Reference No:	2023/62/92778/W
Site Address:	38, Rowley Hill, Common End Lane, Lepton, Huddersfield, HD8 0JF
Description:	Erection of two storey rear extension, alterations to existing porch and other external alterations
Recommending Officer:	Teresa Harlow

Officer Report.

Proposal: Erection of two storey rear extension, reconfiguration of existing roofscape, alterations to existing porch to form first floor terrace

Proposed North Facing
Rear Elevation
Scale 1:100

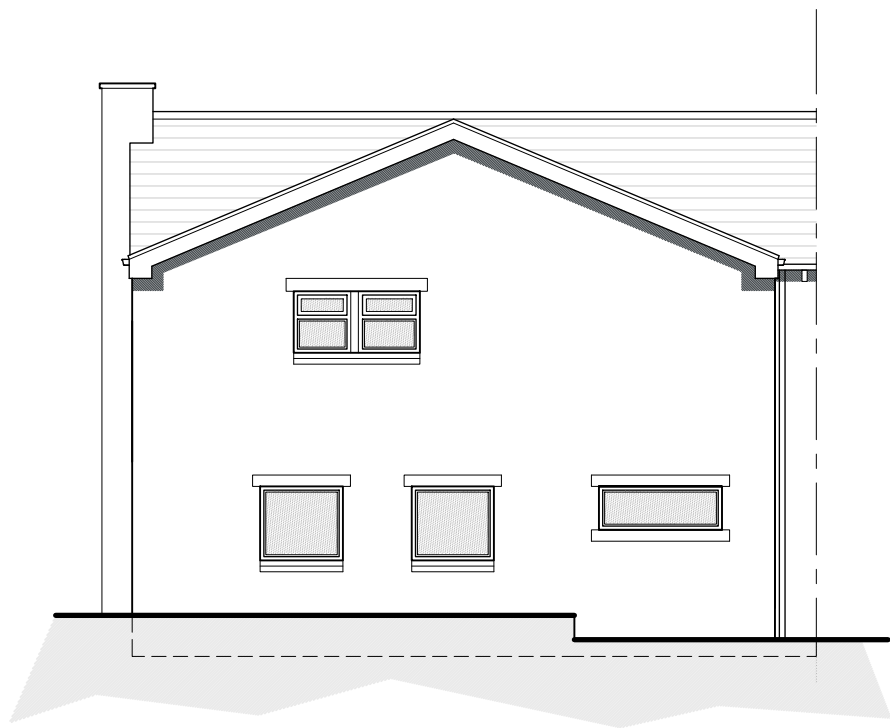
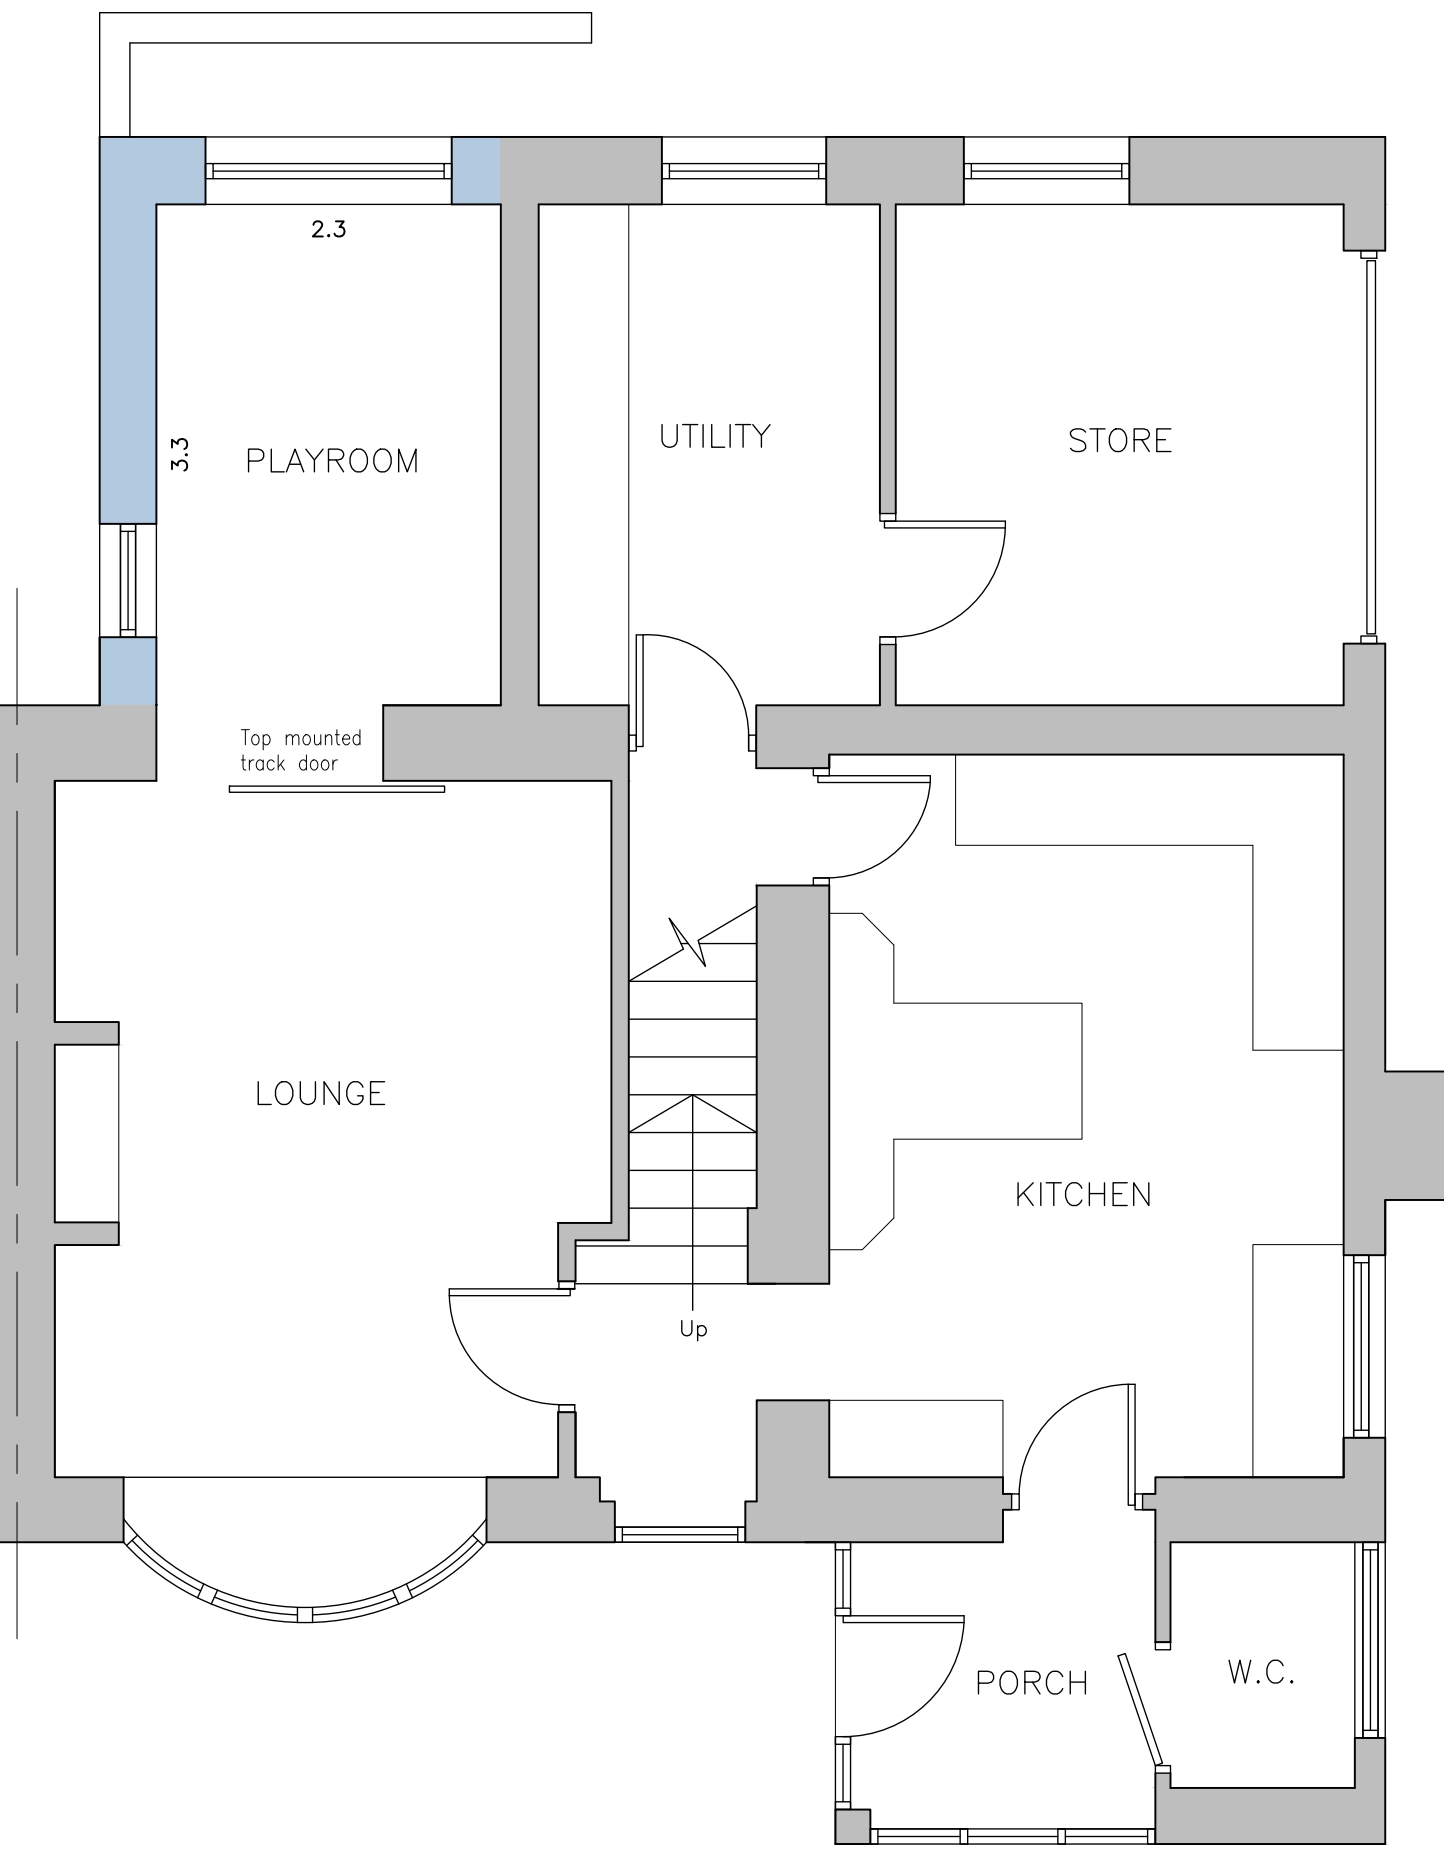
Amended plans were sought to remove a first floor raised terrace to the front of the dwelling, to reduce the scale (height of the two-storey extension) and to remove the proposal to alter the roof form of the existing extension. The request was made to add a Juliet balcony and to cosmetically update the external appearance of the existing two-storey extension. Amendments received.

The cumulative scale and massing of the original two-storey rear extension and roof reconfiguration would have resulted in built form that would not appear as subservient and would result in a loss of character to the existing terrace property. The amended proposal has significantly reduced the scale to remove undue level of bulking and massing, and is now, in this isolated case, no longer out of proportion to the host terrace property or the other terraced properties to which the property adjoins. This takes into account the existing extension and the unique position of the dwelling in a diverse streetscene. It would leave a significant garden area to the front of the dwelling, be proportionate to the dwelling – taking account of the significant curtilage area it enjoys –. Although it extends more than 3m, this aligns with the existing extension and would provide a more cohesive appearance to the development.

The proposed rear extension, whilst somewhat visible from public vantage points around the host property, with the dwelling set in a prominent position within the streetscene would now be more discreet as the proposal has a flat roof that does not extend beyond the eaves, and the roof of the existing extension will remain unchanged. On balance, this has removed the material harm to the character and appearance of the host dwelling in the context of the wider streetscene. Whilst noting the property sits in the context of a row of terraces, which have a relatively cohesive appearance and linear rear elevation to the first-floor level, this is already interrupted by the existing extension. This will be no more materially harmed by completing the rear extension in this case. Other properties along the row do not have the significant rear garden area that this dwelling has and so the likelihood of this being replicated is unlikely.

The proposed windows in the western elevation of the extension serve a playroom and bedroom 3. The playroom window would not look towards any window in the rear of no. 40. The first floor windows are indicated to be obscure glazed, which, subject to condition is considered to be acceptable.

4.The development shall not be occupied until the first floor windows within the west elevation of the rear extension hereby approved have been obscure glazed (minimum grade 4). Notwithstanding the provisions of the Town and Country Planning (General Permitted Development) (England) Order 2015 as amended (or any Order revoking or re-enacting that Order) the windows shall be retained obscure glazed thereafter.
